DECISION DELEGATED TO HEAD OF PLANNING

Application No:	H09-0011-26	Applicant:	Mr & Mrs J Pateman
Proposal:	Proposed Domestic Garage		
Location:	Lowlands Hurn Bank Holbeach Hurn		
Terminal Date:	12th March 2026

PROPOSED ELEVATIONS 1:100

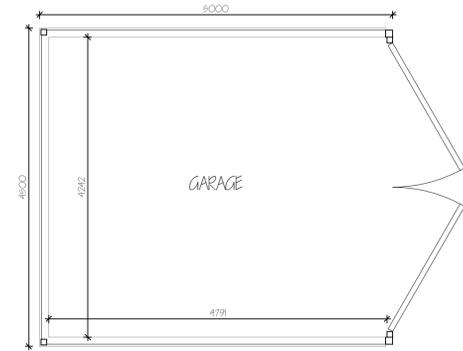
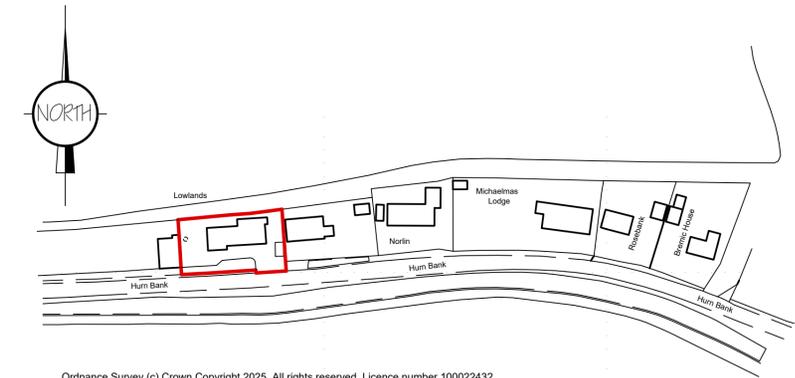
The garage is proposed to measure 5m by 4.5m featuring a gable end roof form that measures 3.5m in height up to the building ridgeline. The external materials are not set out within the submitted elevation plans; however, the materials are indicated on the application form including oak frame featheredge boarding for the walls and a slate roof.

SITE PLAN - PROPOSED 1:100

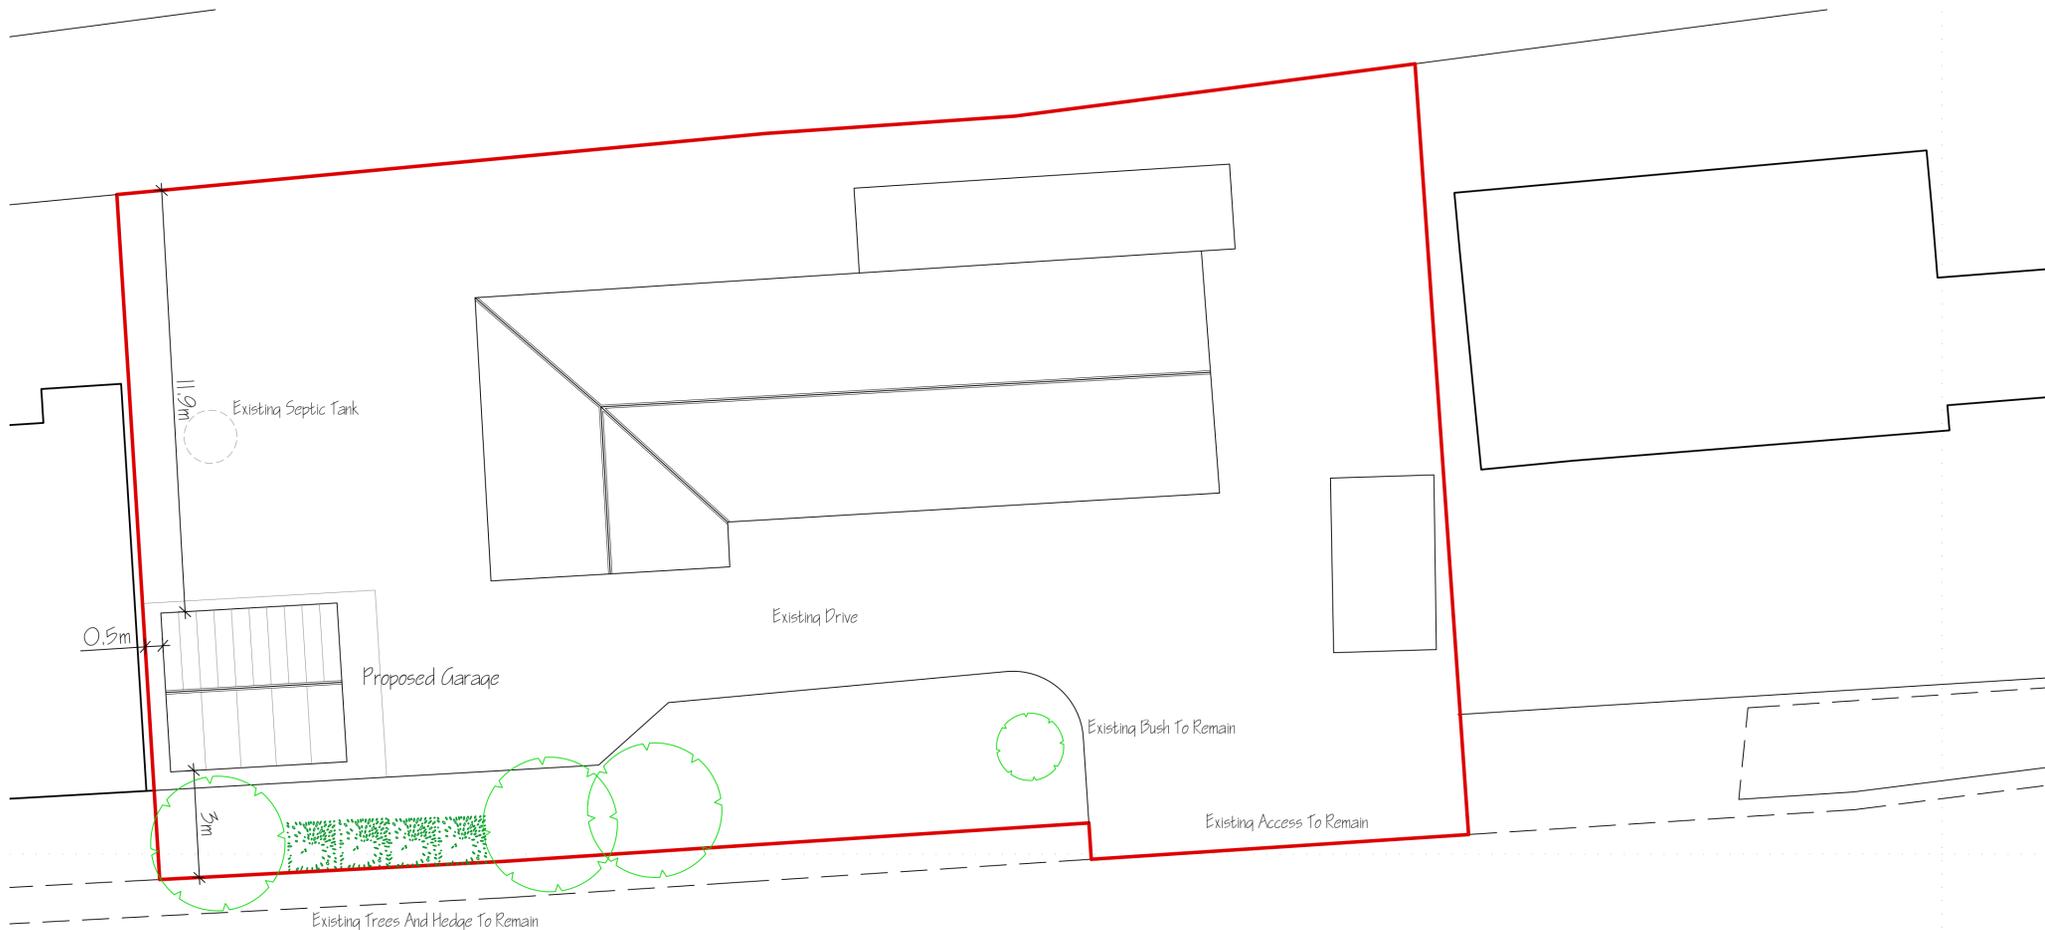
Whilst the size of the garage building is considered to be proportionate to the host dwelling, there are concerns with the proposed siting of the building due to its position in front of the dwelling. The nearest dwellings are set back from the road frontage at similar distances and there are no other garages or outbuildings located in front of the nearest dwellings. Whilst there is a storage container located within the site to the front of the dwelling, it appears that this does not have planning permission. As such, this is not considered to be a permanent fixture within the street scene. The site slopes down from the road frontage and as such, the garage building would be positioned on lower land than the road frontage. Notwithstanding this, the building would still be highly visible within the street scene. This is particularly the case since vegetation has been cleared along the site frontage which previously provided more screening.

The proposed structure would be an unduly prominent and incongruous feature in the street scene due to its position in front of the dwelling and its proximity to the highway. The negative visual impact would be further exacerbated by the absence of other buildings in front gardens and driveways areas within the vicinity of the site. Permitting the development in this instance could set a harmful precedent for allowing similar structures in front of dwellings, which could detract from the character and appearance of the area.

The concerns with the proposals were raised with the applicant's agent and the agent was offered the opportunity to consider alternative locations such as to the side of the dwelling. However, the agent did not opt to submit any amended plans.
